Our Ref: R/26/20/HH
Your Ref:

Town & Country Planning Act 1990 (as amended)
Town & Country Planning (Development Management Procedure) (England) Order 2015
Application for Planning Permission for Works or Extension to a Dwelling

Development Rear extension
New roof with dormers to front and rear
Location Windsong The Thatchway Rustington

Block Plan
Scale: 1:500

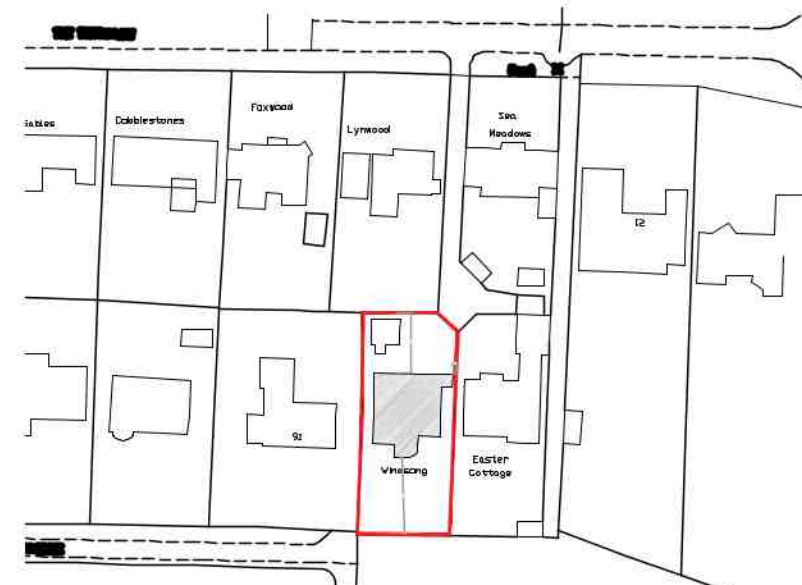
Dimensions: You are required to include dimensions on the block plan from the proposed extensions to the site boundaries.
